127 Pleasant Ave

**Ann Machado - RE: Permit #2014-02674 - 127 Pleasant Ave.**

# General Building Permit Application

New Garage Plan

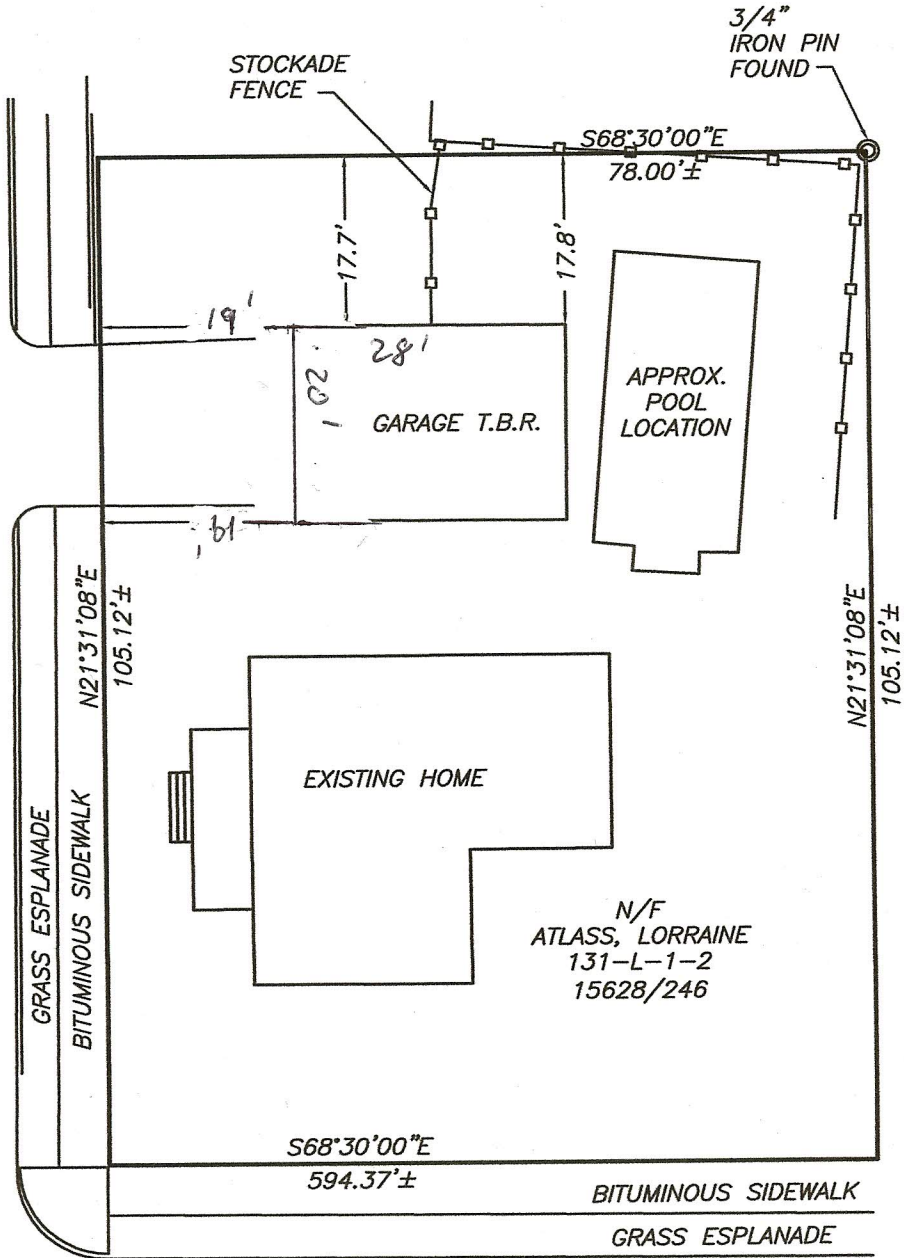
Thanks Shawn. The one other question I have is that the garage does not seem to run exactly parallel to the rear property line. It is 17.7' at the existing front corner. What is exact measurement from the front corner of the new garage?

2. The garage is currently nonconforming to the rear setback of 20'. You are increasing the nonconformity of the rear setback by adding 6' on to the garage. We talked about you using section 14-433. To use that section you have to make an argument of why you can't move the garage to be 20' off the rear property line. Also you need to explain why it is necessary to add 6' to the garage.

while looking at the survey we provided, it seems to me that it shows the garage as it sits now as gaining only one inch over a 22 ft. span relative to the length of the garage. I couldn't imagine that it would gain that much in a six ft. span. Taking into consideration that six ft. is less than a quarter of 22ft., I would say that the set back would change by not more than a quarter inch thus making the new garage set back approximately 17.675 ft. please contact me if you need further explanation. Thank you Shawn

This is our argument for keeping the garage at its current position relative to the rear set back. Assuming that the front of the house is on pleasant Ave. the existing garage is currently 17.7' from the rear set back. To Move it into position to make it meet the rear set back of 20 ft. it would result in making the walkway to the pool area to narrow. It would also encroach on the house and make things look way out of place. In keeping with trying to make the property as original as possible and not upset flow and already existing landscaping we propose the garage stay in the setbacks is ii currently.

We propose an addition of six feet to the front of the garage so that it will accommodate the homeowner's current vehicles. We can't add to the back as there is a pool directly behind the garage. This addition will remain within the current side set back rules for r-5 zone with room to spare.

CROSS SECTION

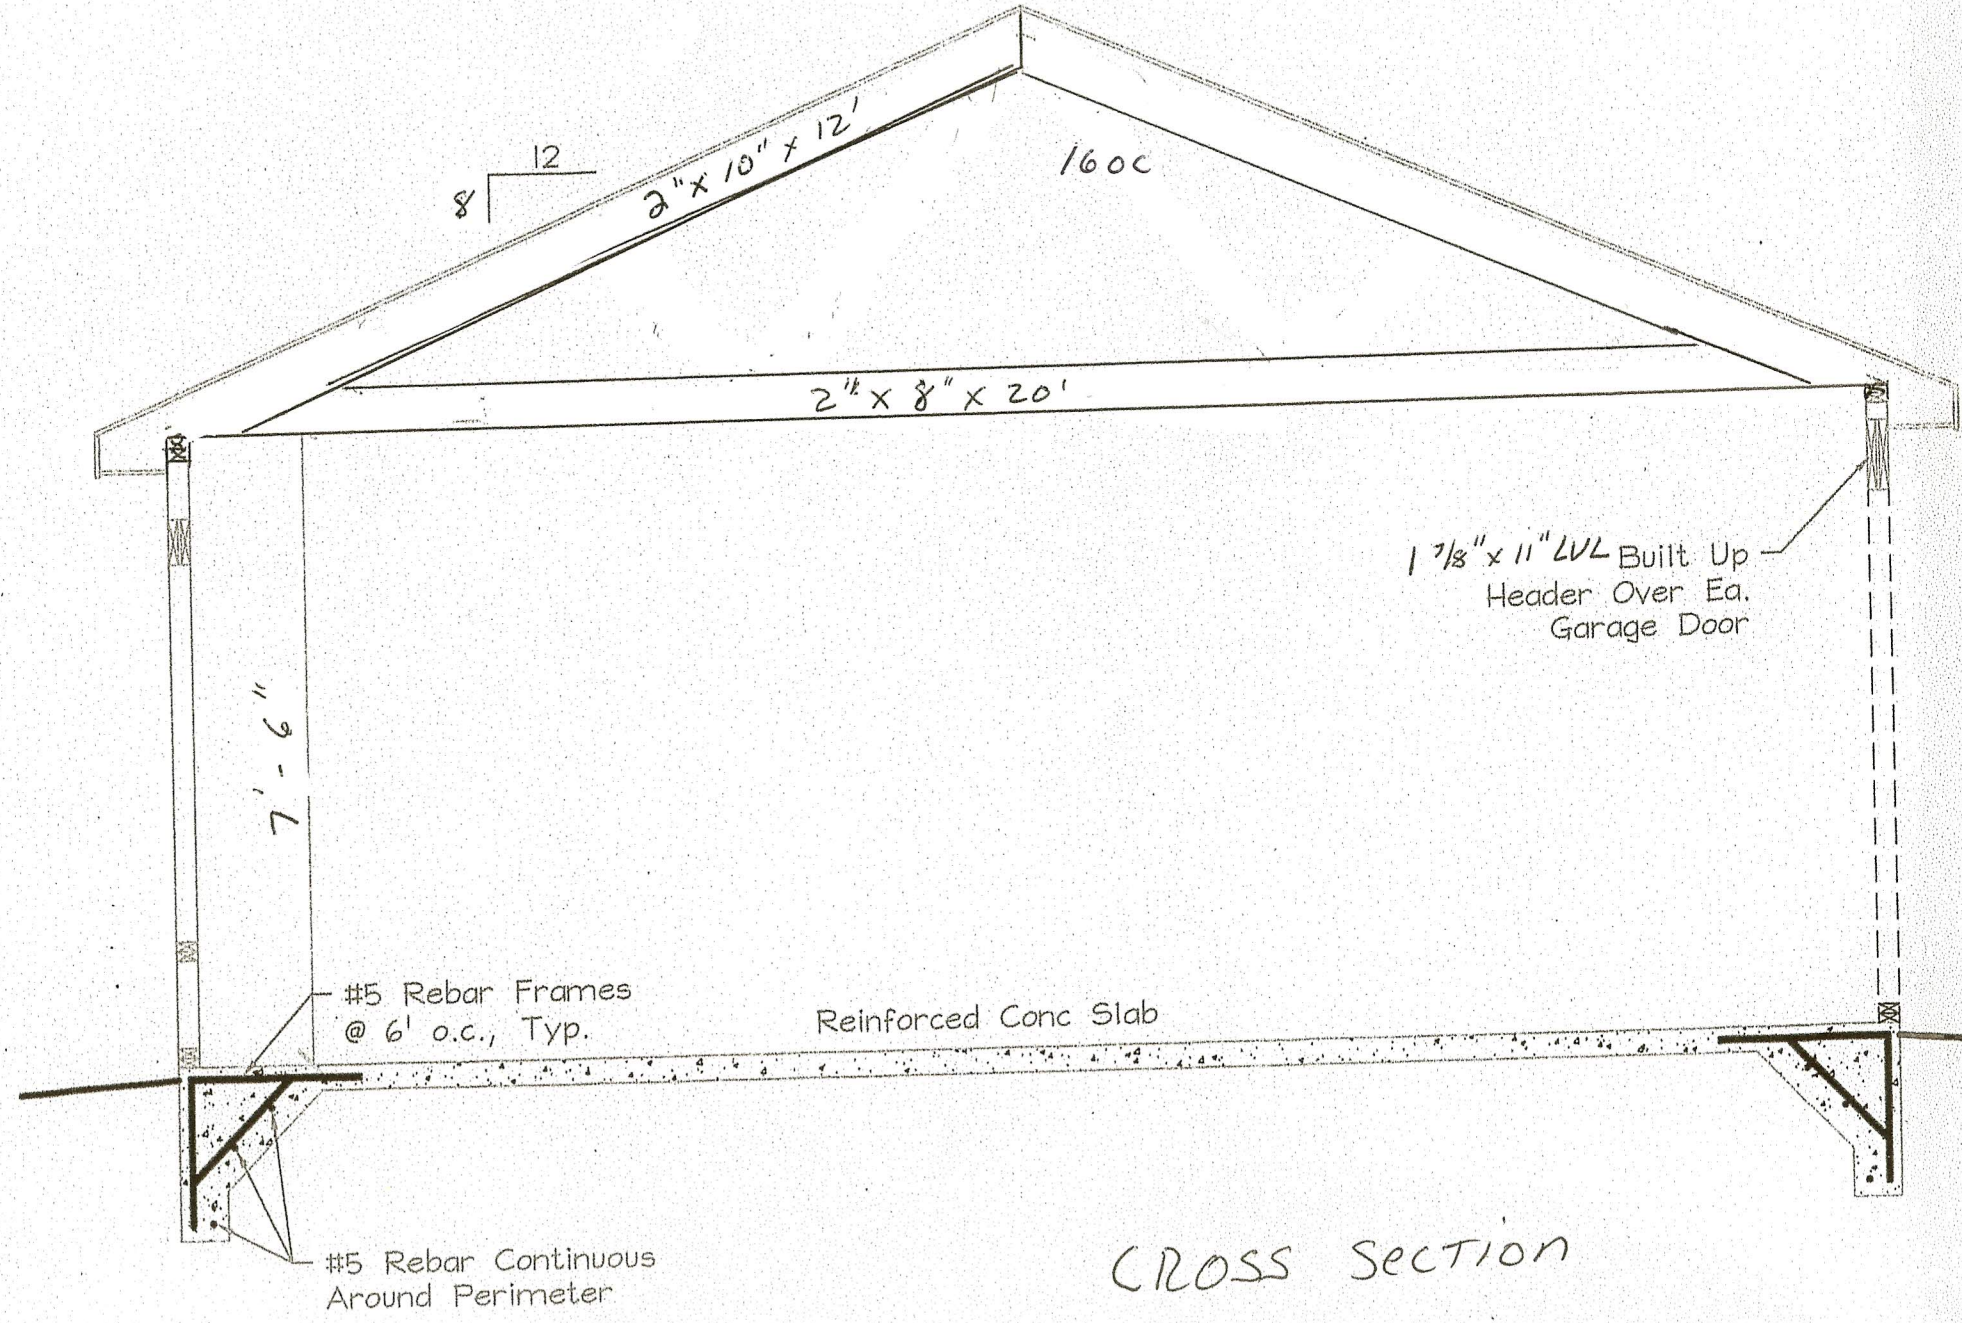
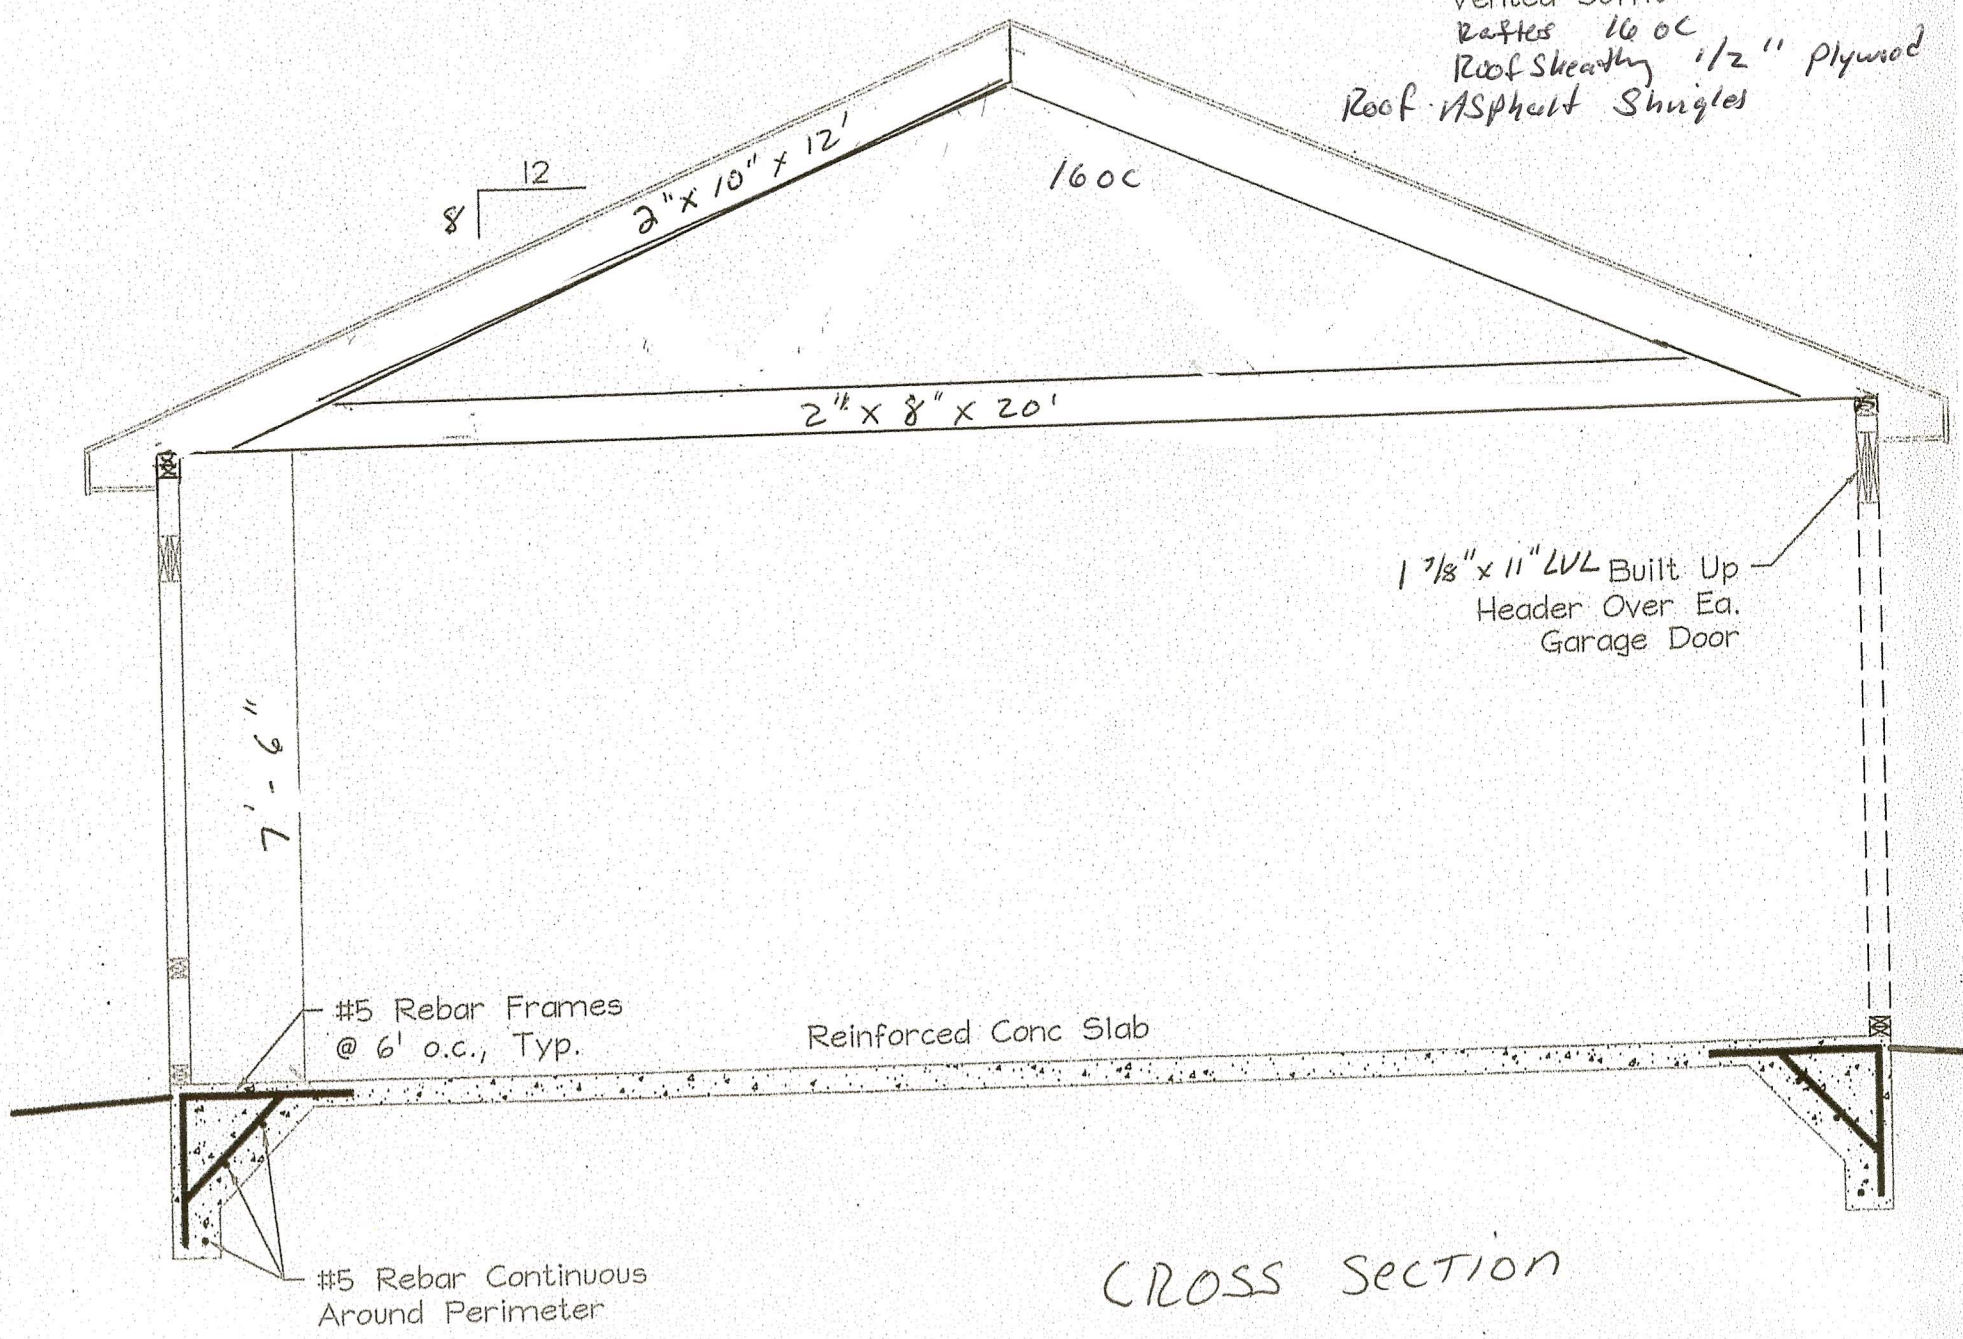
<b>Pitch, Span, Spacing &amp; Dimension (Table R802.5.1(1) - R 802.5.1( 8))</b> <b>Roof Rafter; Framing &amp; Connections (Section R802.3 &amp; R802.3.1)</b>		
<b>Sheathing; Floor, Wall and Roof (Table R503.2.1.1(1))</b>	Requested roof sheathing	OK per revised plans
<b>Fastener Schedule (Table R602.3(1) &amp; (2) )</b>		
<b>Private Garage</b> (Section R302.5) <b>Living Space (Above or beside)?</b>		
<b>Table R302.6</b> <b>Fire separation (Section R302.6)</b>		
<b>Opening Protection (Section R302.5.1)</b> <b>Minimum Height (Section R305.1)</b>		
<b>Emergency Escape and Rescue Openings (Section R310)</b>	NA	
<b>Roof Covering (Section R905)</b>		
<b>Safety Glazing (Section R308)</b>	NA	
<b>Attic Access (Section R807)</b>	NA	
<b>Chimney Clearances/Fire Blocking (Chap. 10)</b>	NA	
<b>Header Schedule (Tables R502.5(1) &amp; (2))</b>		
<b>Energy Efficiency IECC, 2009</b> <b>R-Factors of Walls, Floors, Ceilings, Building Envelope,</b> <b>U-Factor Fenestration</b> <b>Ventilation of Space per ASRAE 62.2, 2007</b>	NA
